# A303 Sparkford to Ilchester Dualling Scheme TR010036

## 8.1 Statement of Common Ground with Environment Agency

**STATEMENT OF COMMON GROUND**

2.11 Outline Drainage Works Plans

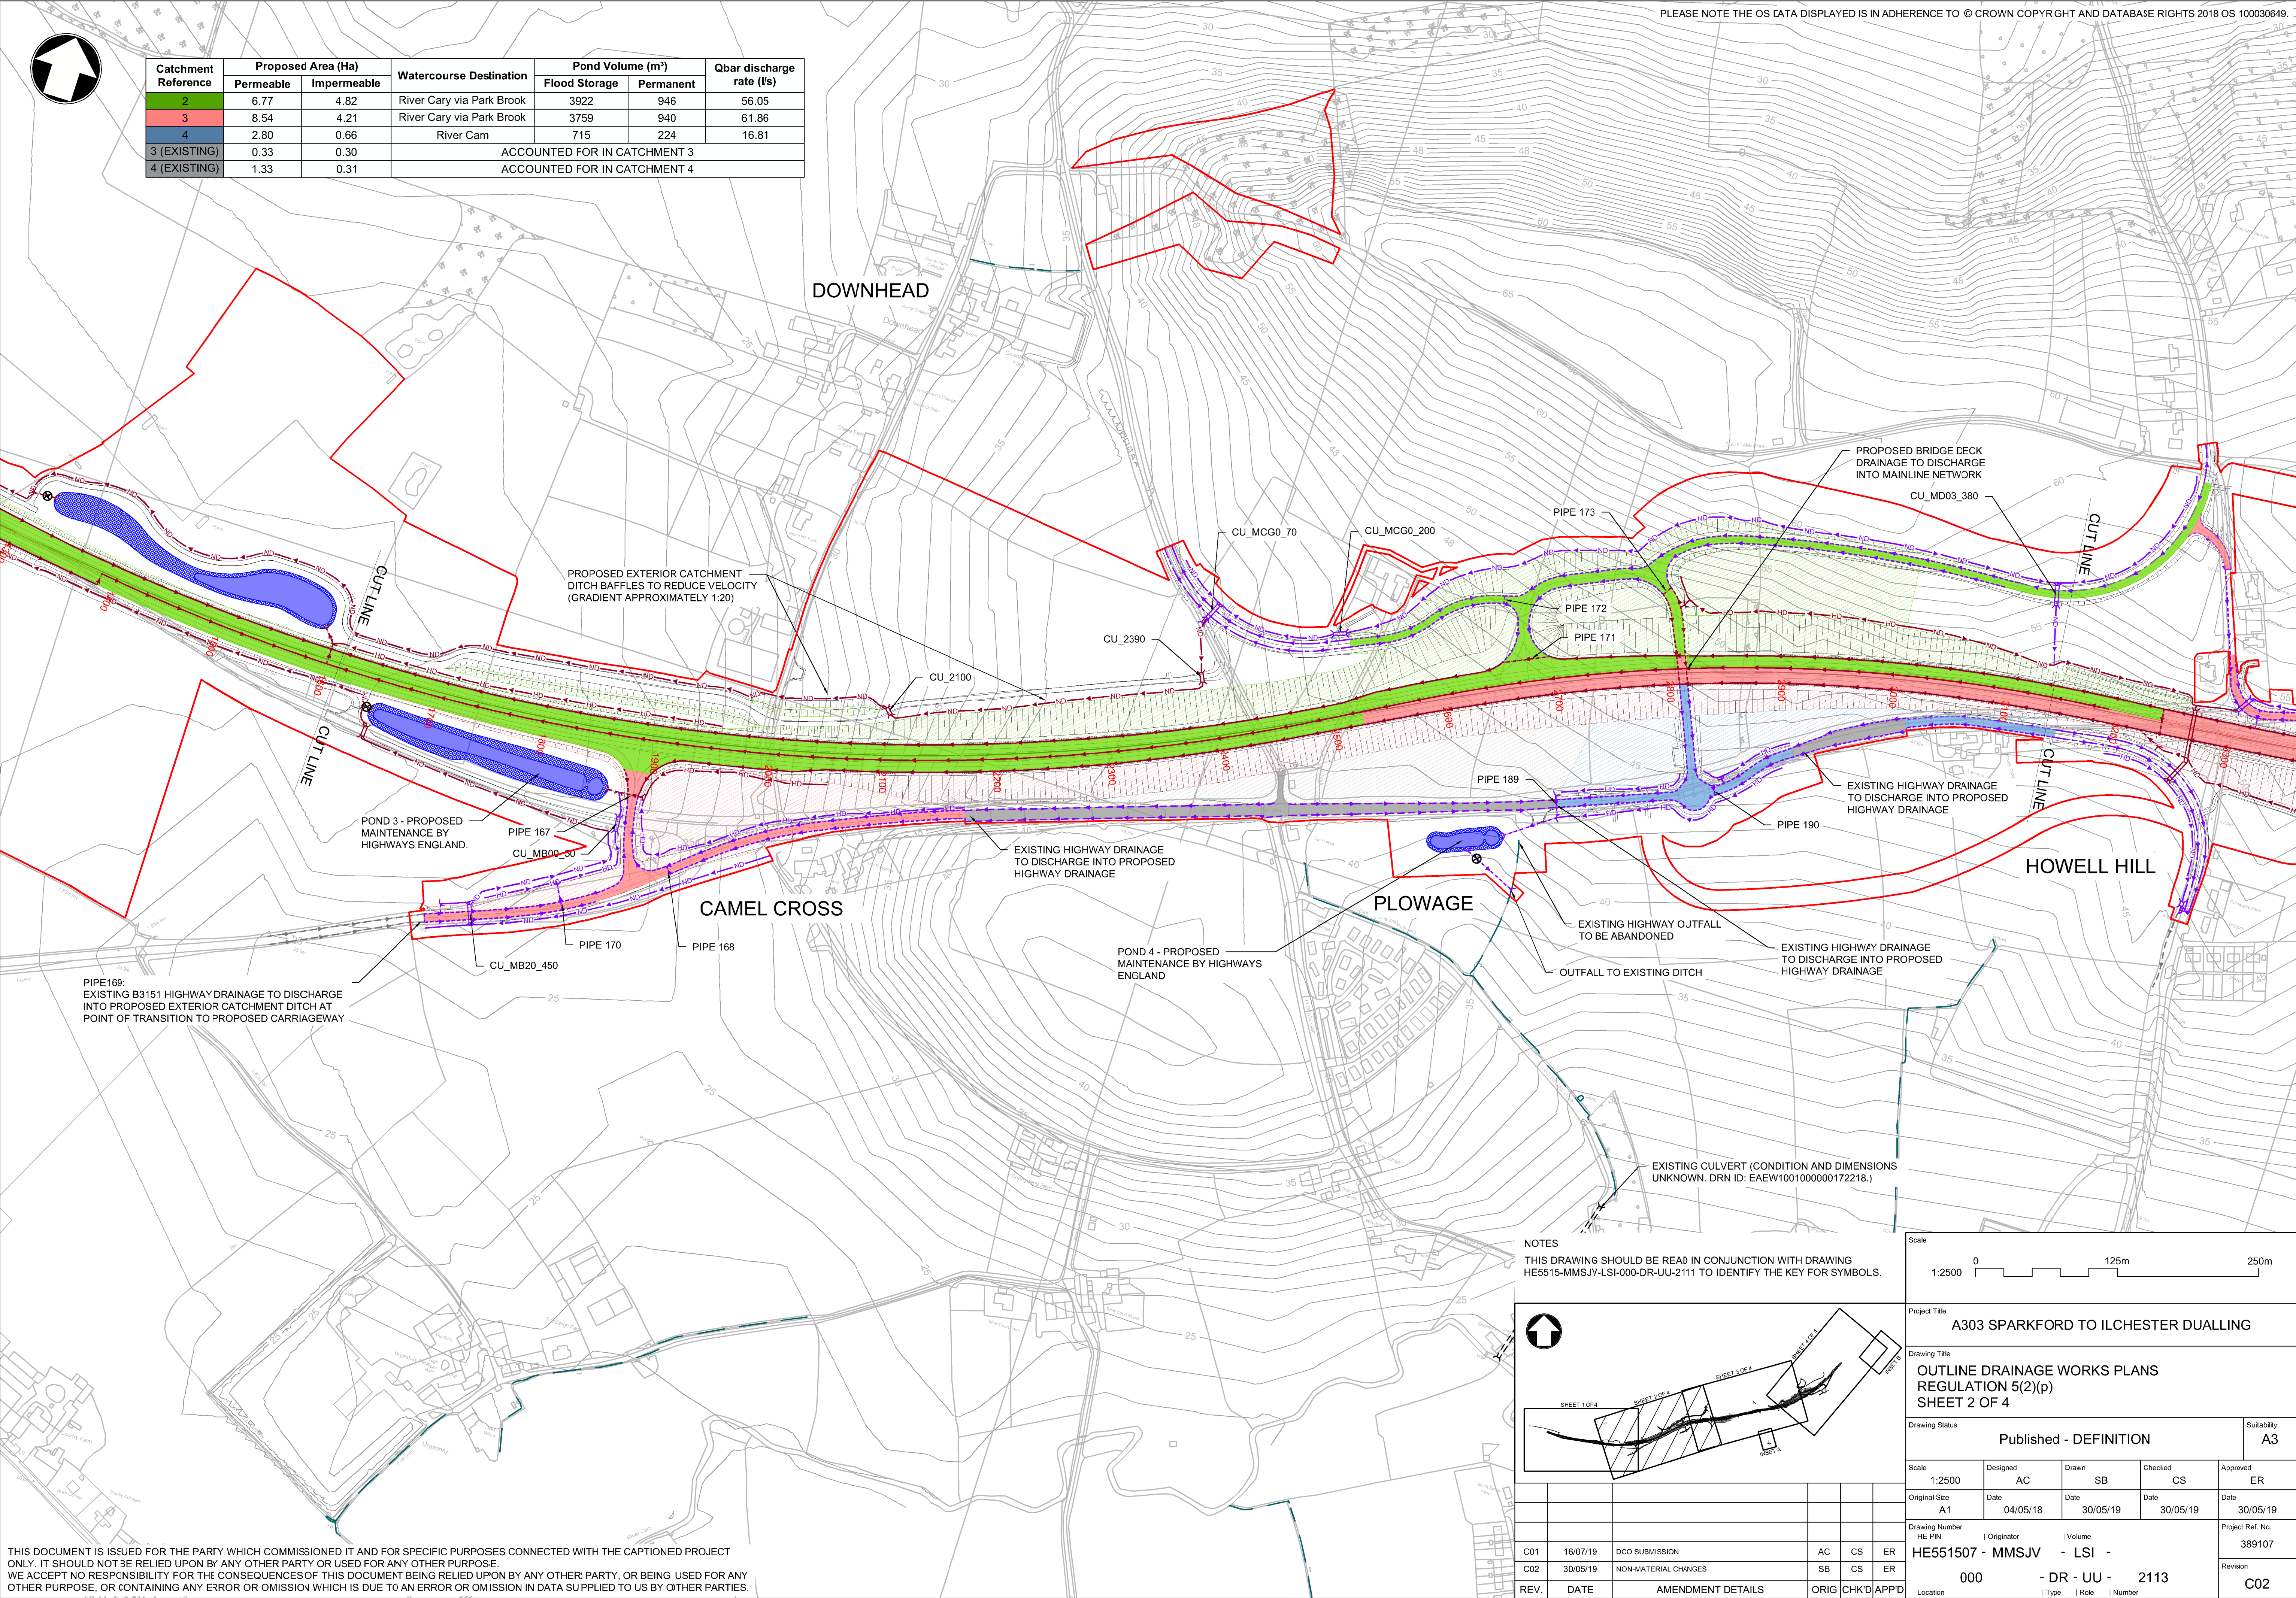
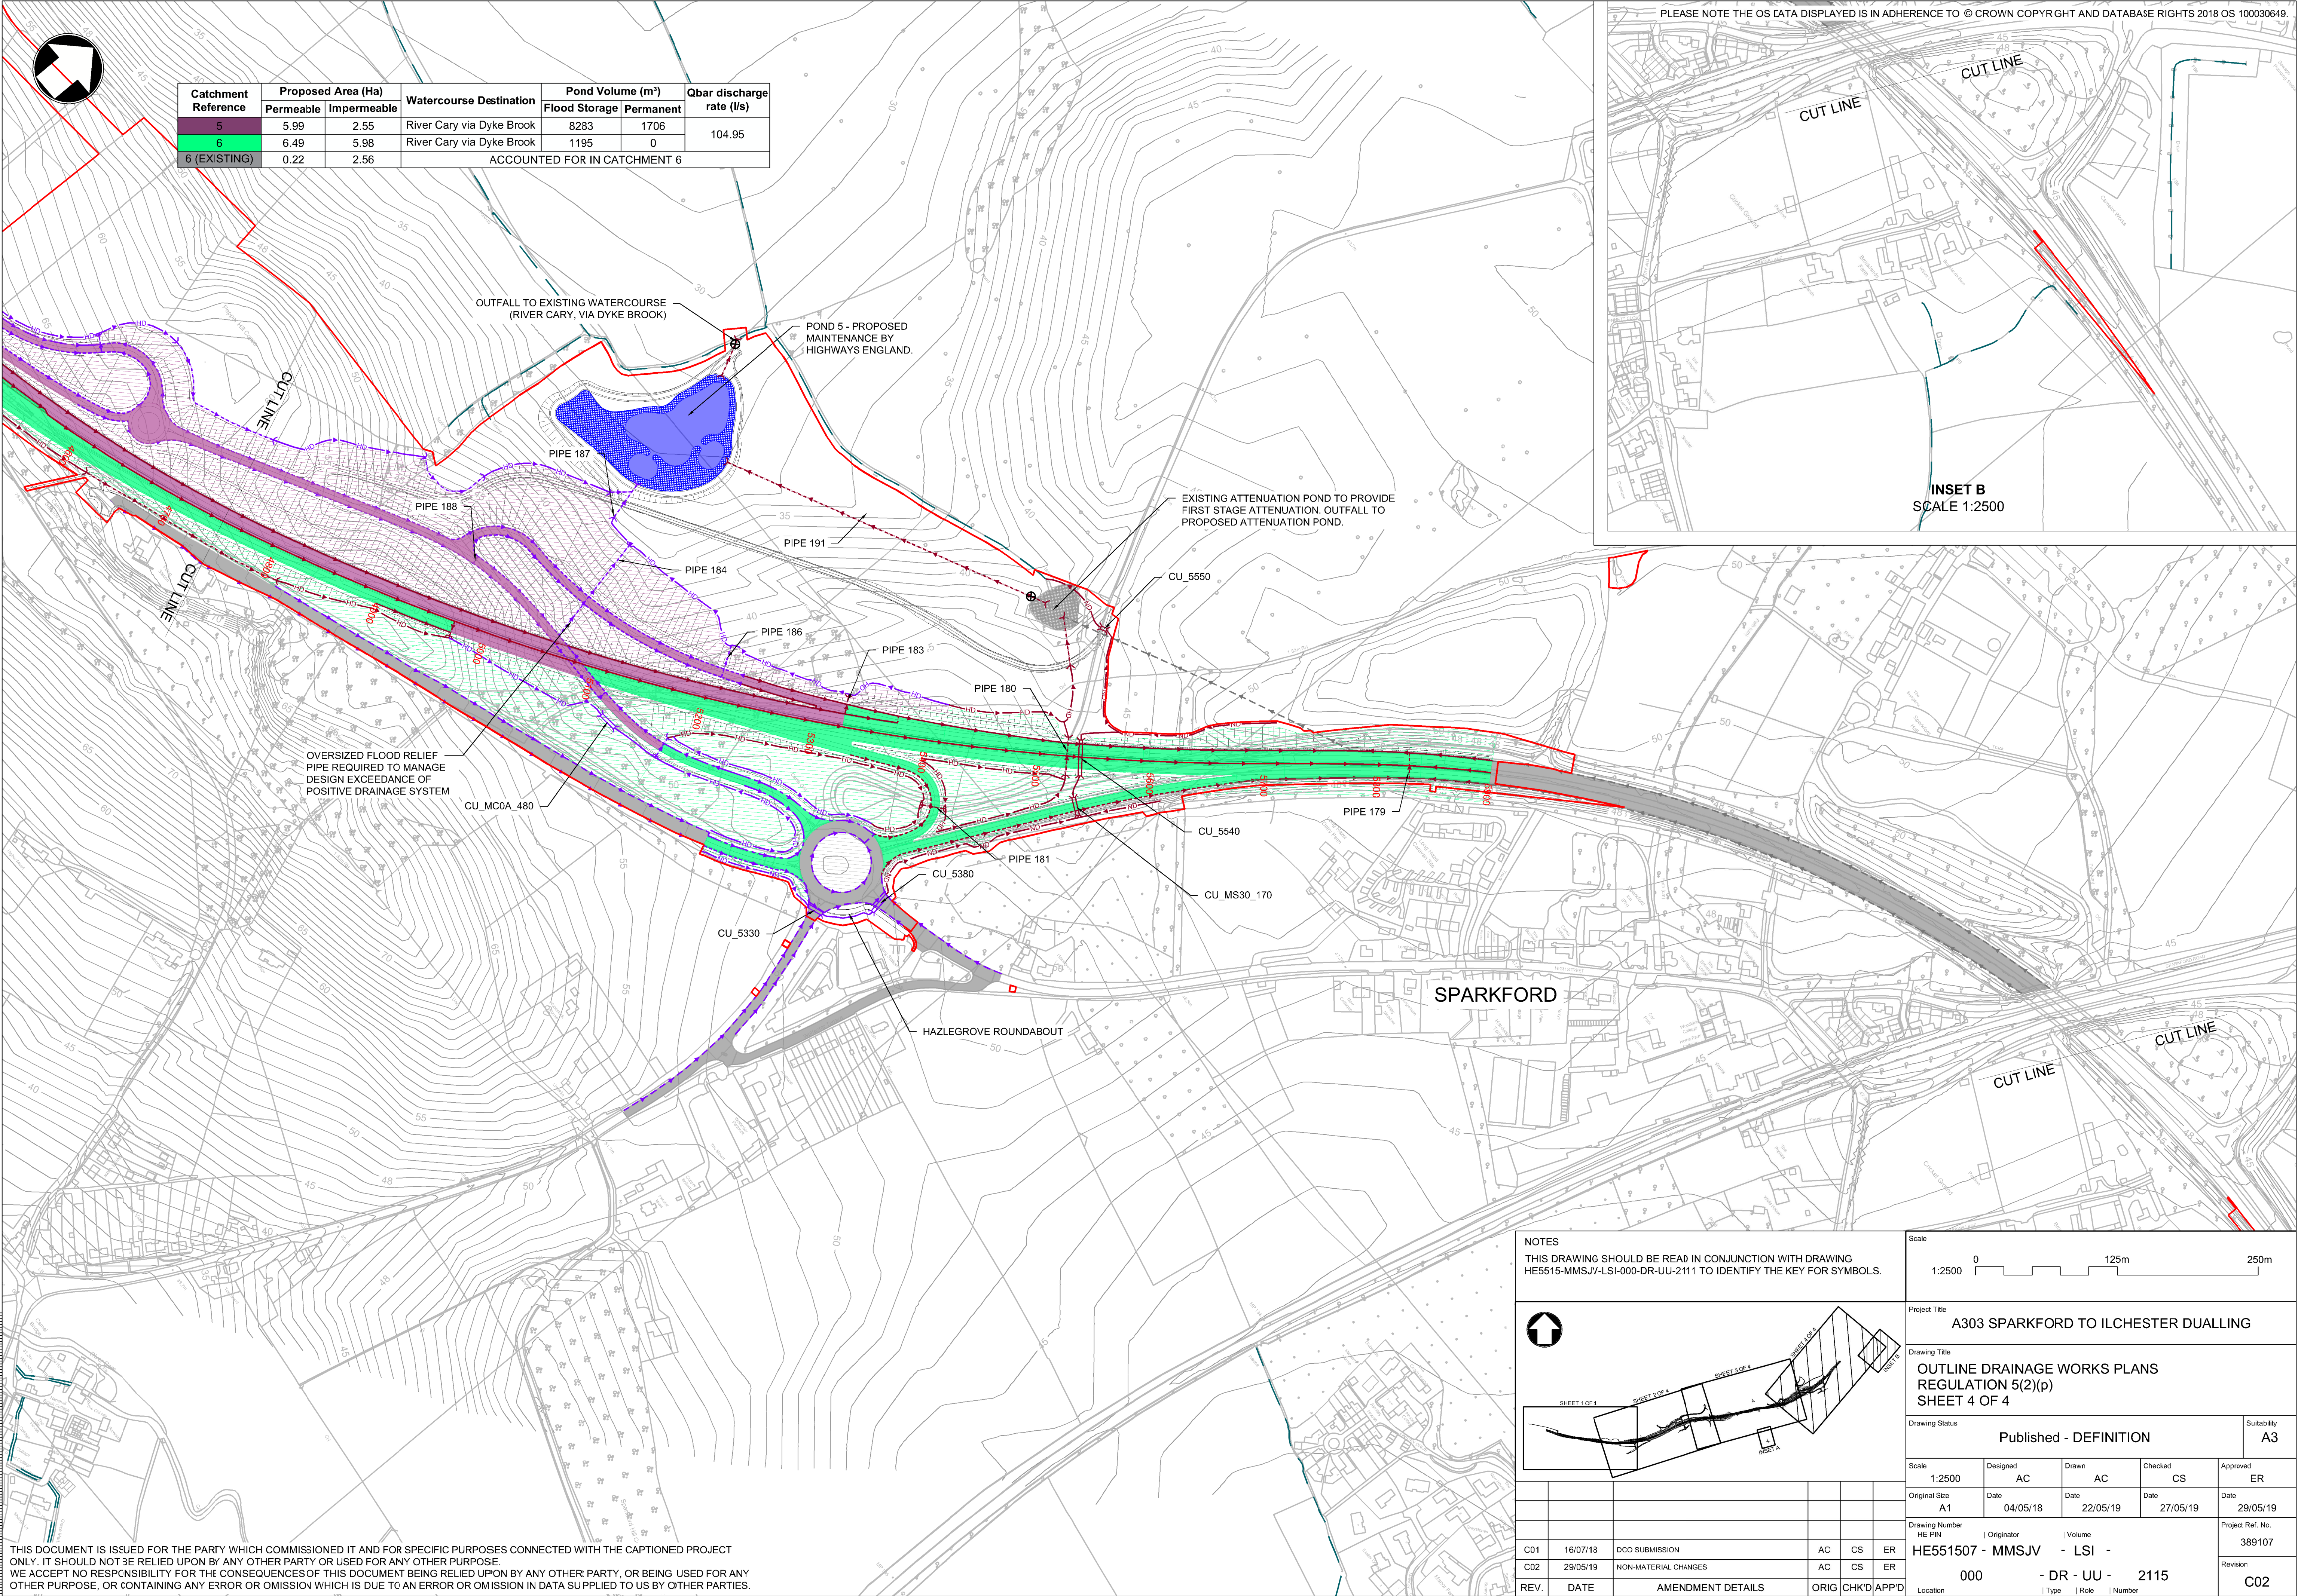
Topic	Sub-section	Environment Agency comment	Highways England response	Status
		Confirmation is sought that the proposed design will control the overall volume, as well as the overall rate of runoff with sufficient attenuation provided.	Attenuation has been provided, with discharge limited to 1% annual exceedance probability (1 in 100-year event) plus 40% to account for the effects of climate change (Flood risk assessments: climate change allowances, Environment Agency), to no greater than the undeveloped rate of runoff, determined by the calculation of the mean annual peak rate of runoff for a greenfield site (Qbar).  Preliminary design discharge rates and volumes shown in Outline Drainage Works Plans (document reference <b>TR010036/APP/2.11</b> ).	<b>AGREED</b> <i>(see letter contained in Appendix A)</i>
		With reference to flood risk management issues, the documentation does not include the Agency's confirmation that the proposed route is located outside designated flood zones 2 and 3 and is therefore not liable to any significant main river fluvial or tidal risks. The highlighted risks are from surface water and or IDB/ordinary watercourses.	The Flood Risk Assessment considers all sources of flood risk, including but not limited to the fluvial and tidal flood zones, ordinary watercourse and surface water runoff. Evidenced in Flood Risk Assessment (Appendix 4.6 of <b>TR010036/APP/6.3</b> ).	<b>AGREED</b> <i>(see letter contained in Appendix A)</i>
